# Frodsham Solar

## Statement of Common Ground with the Environment Agency

April 2026

PINS Ref: EN010153  
Document Ref: EN010153/DR/8.17  
Planning Act 2008; and Infrastructure Planning (Applications:  
Prescribed Forms and Procedure) Regulations Regulation 5(2)(q)

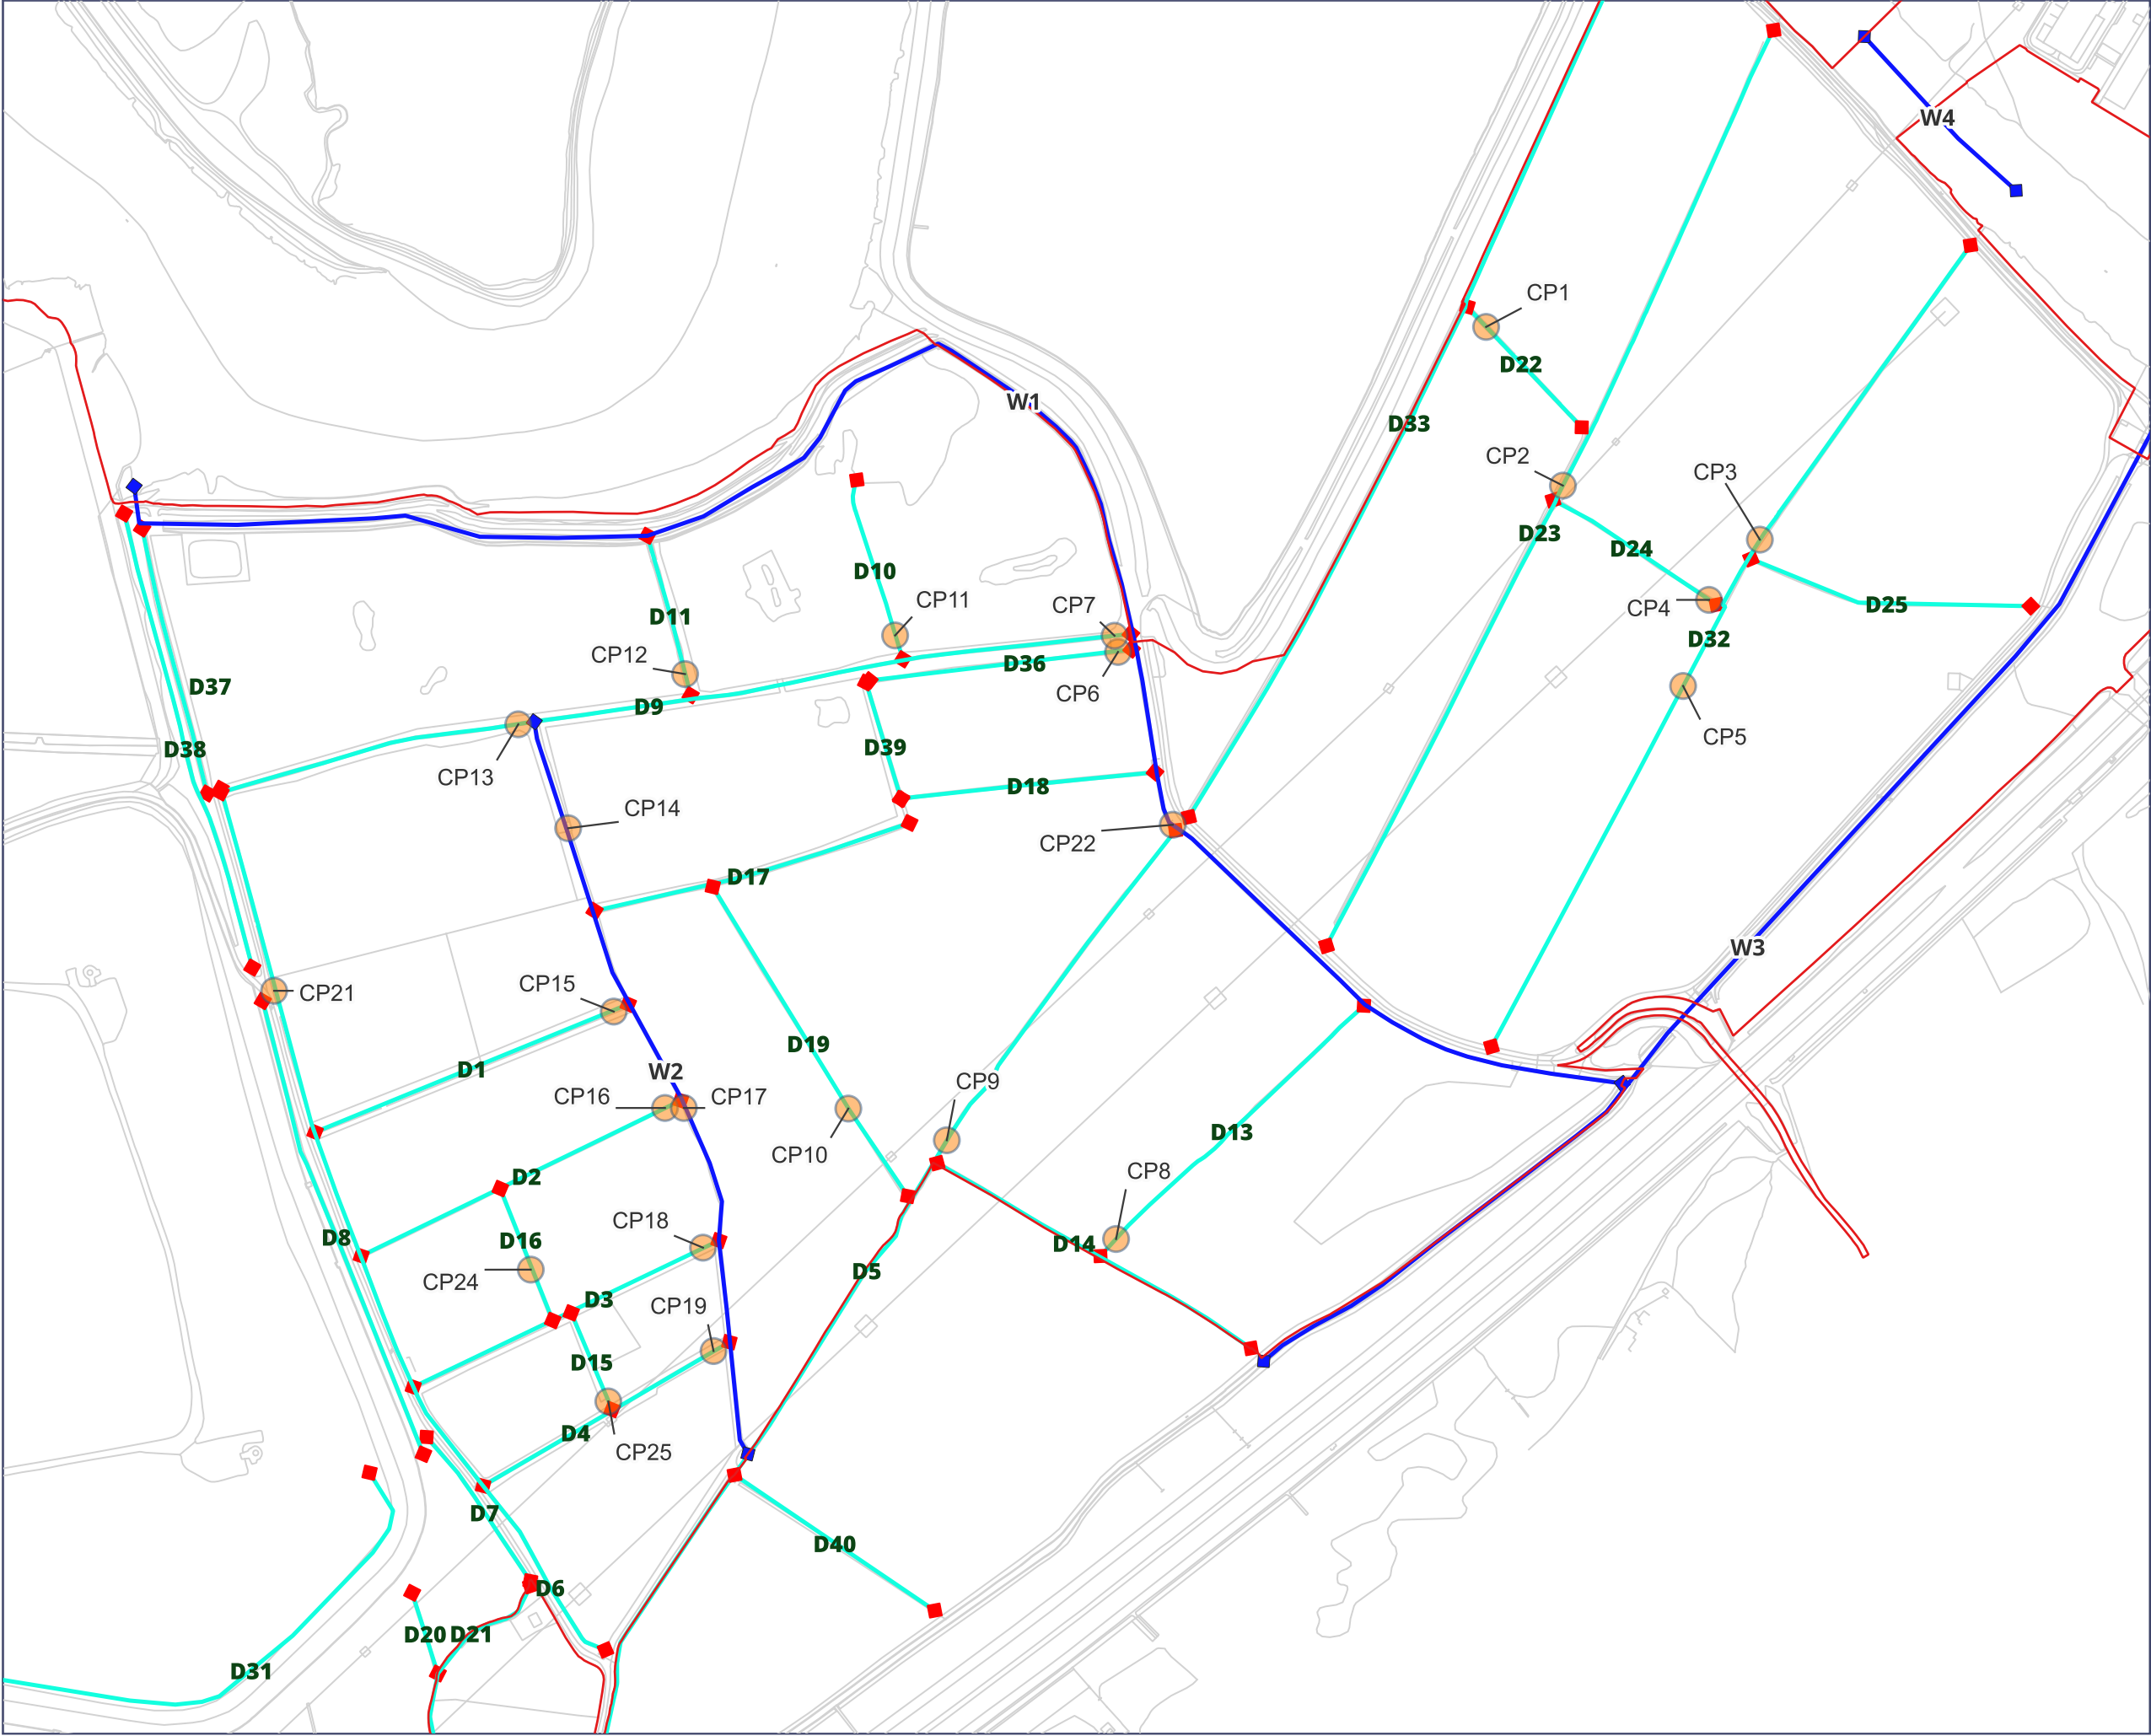
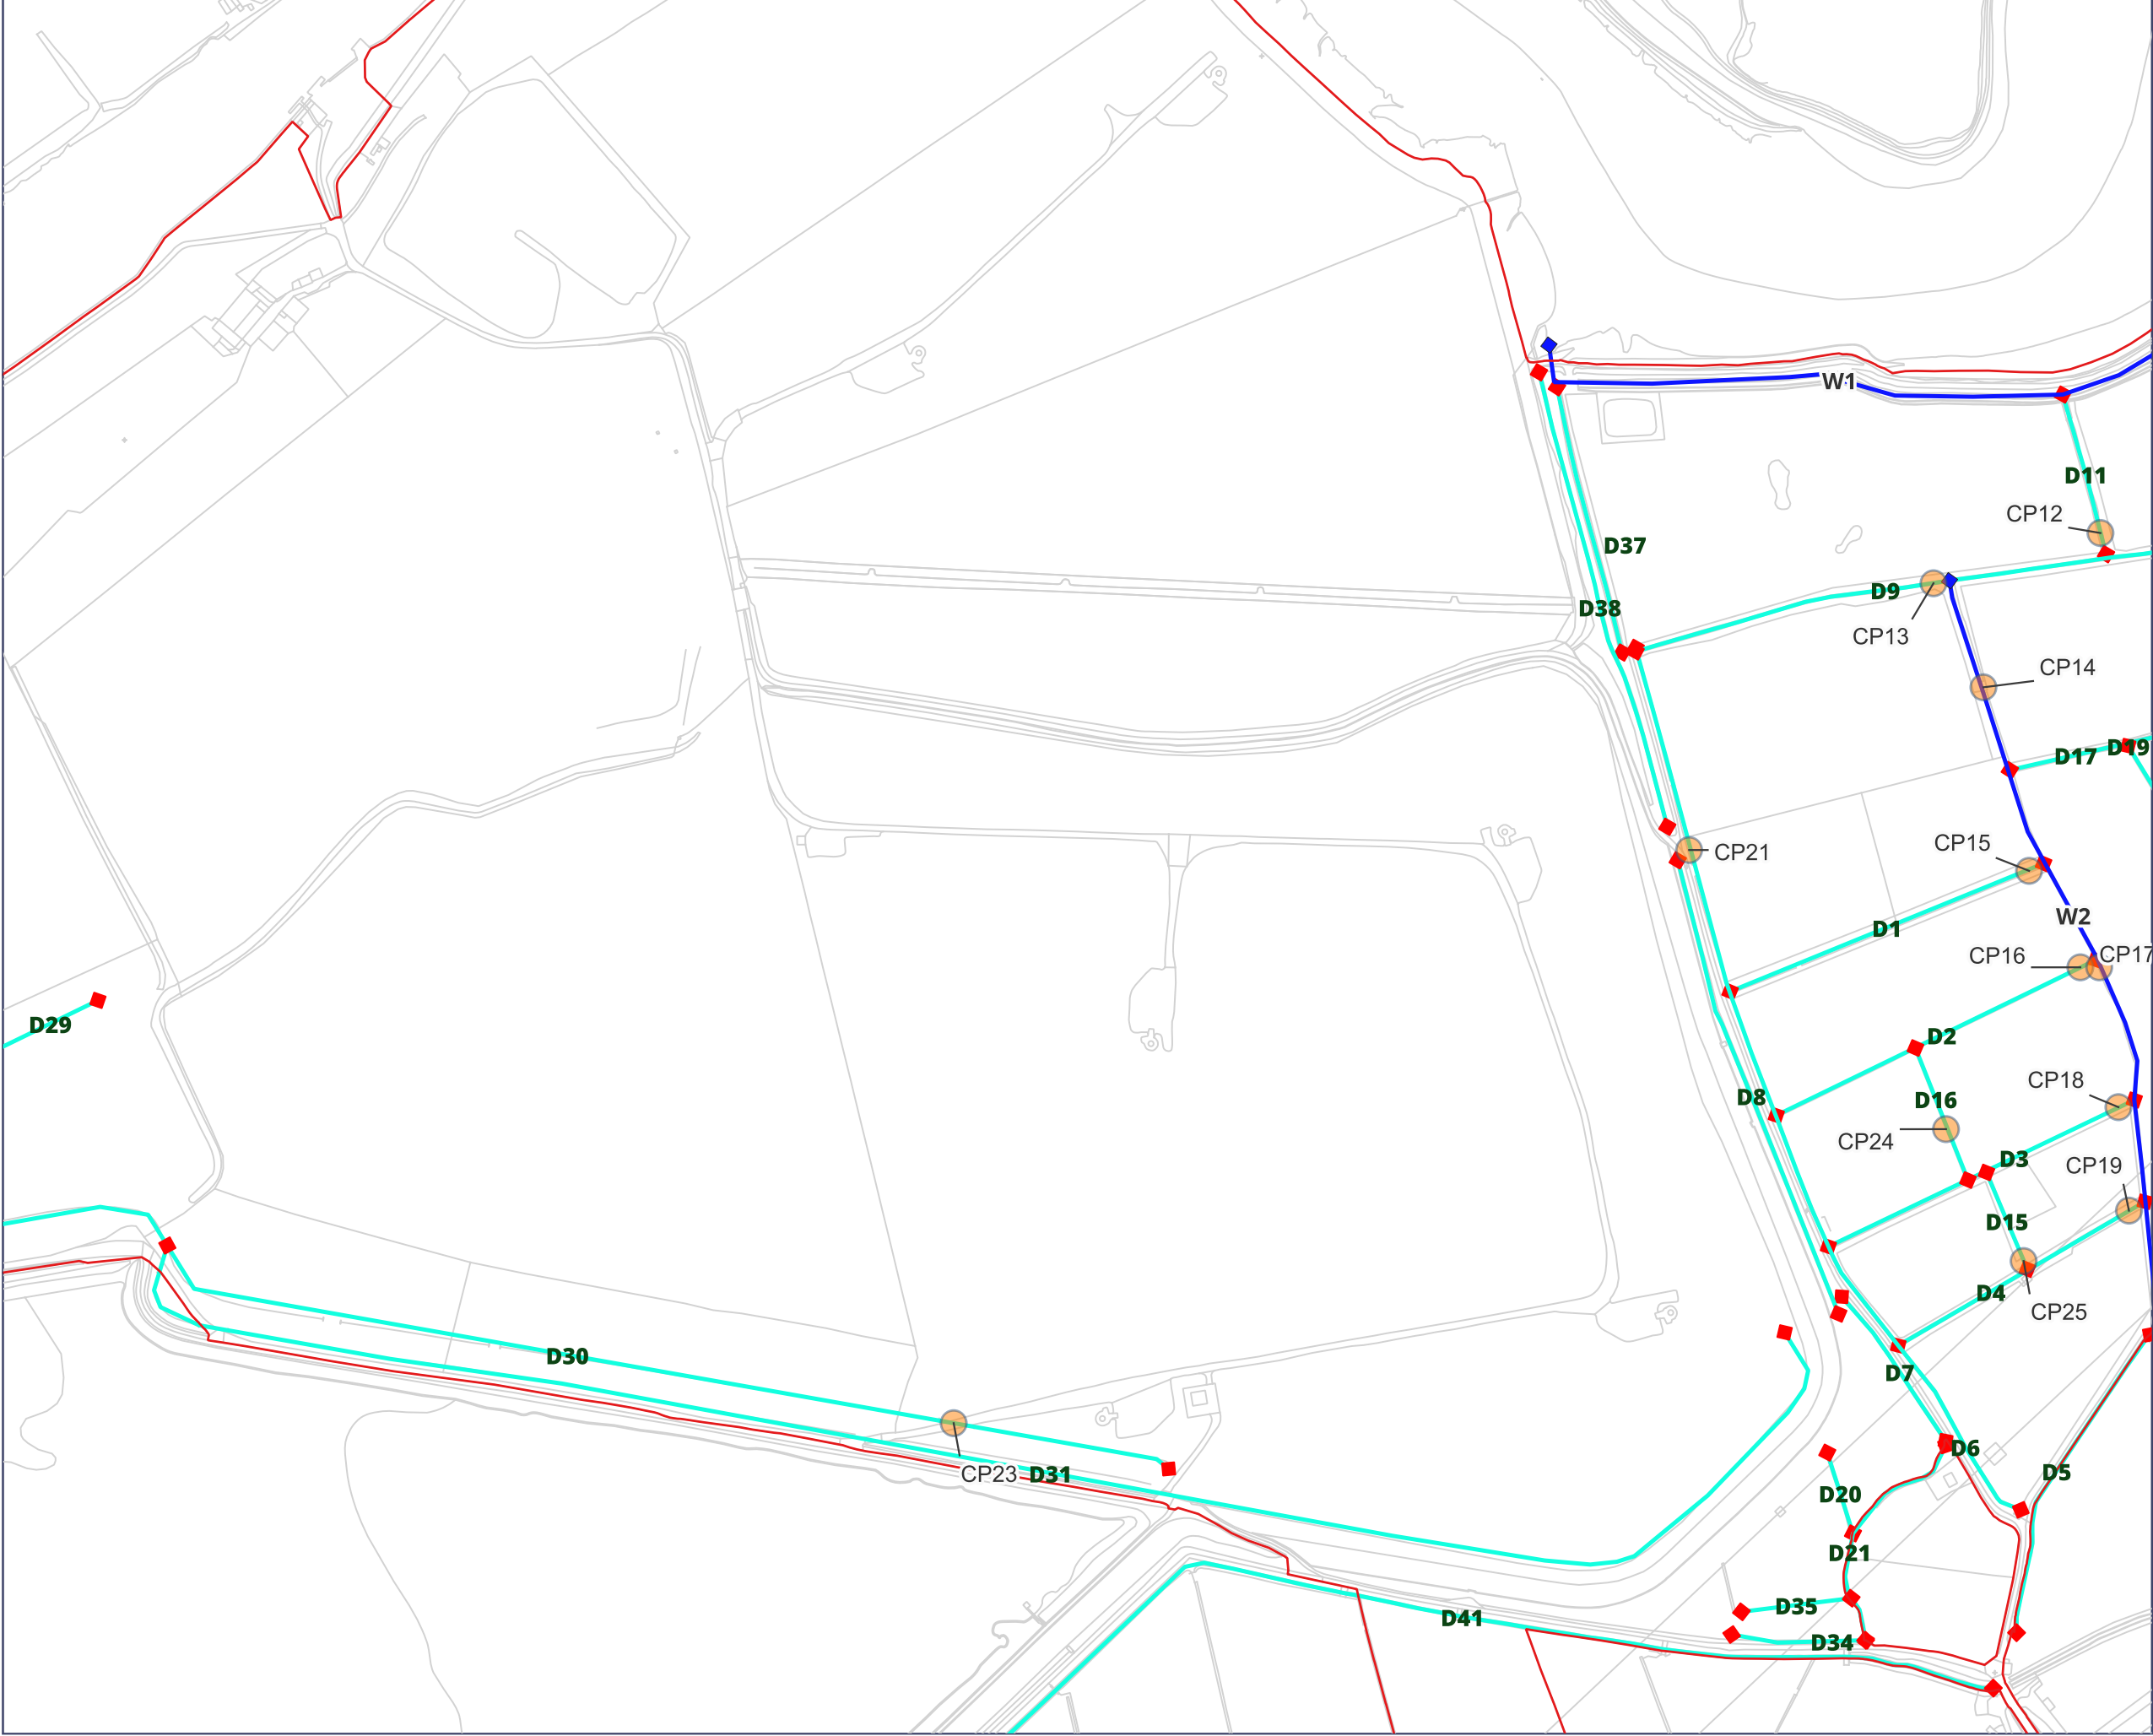
Ref.	Matter	EA Position	Applicant Position	Status
012	<p>The Applicant's approach to designing watercourse crossings.</p> <p><i>EA Issue ID: EA007</i></p>	<p>The EA has concerns about the position of bridge abutments and soffit levels, and that these will reduce conveyance of water during high flow conditions, preclude access to, and threaten the stability of the riverbanks.</p> <p>The EA request that a soffit level at least 0.6metres is provided from the bank top, as set out in the Standard rules SR2015 No 28 guidance. The EA require a 2m offset for the abutments to ensure that geomorphological processes aren't impacted.</p> <p>The EA has requested that the Applicant provides a 600mm freeboard between the bridge soffit and top bank level for CP14 and CP17, and a 300mm freeboard at CP21.</p>	<p>The Applicant has provided drawings for CP14, CP17 and CP21 demonstrating that the required freeboard can be provided.</p>	Matter Agreed.
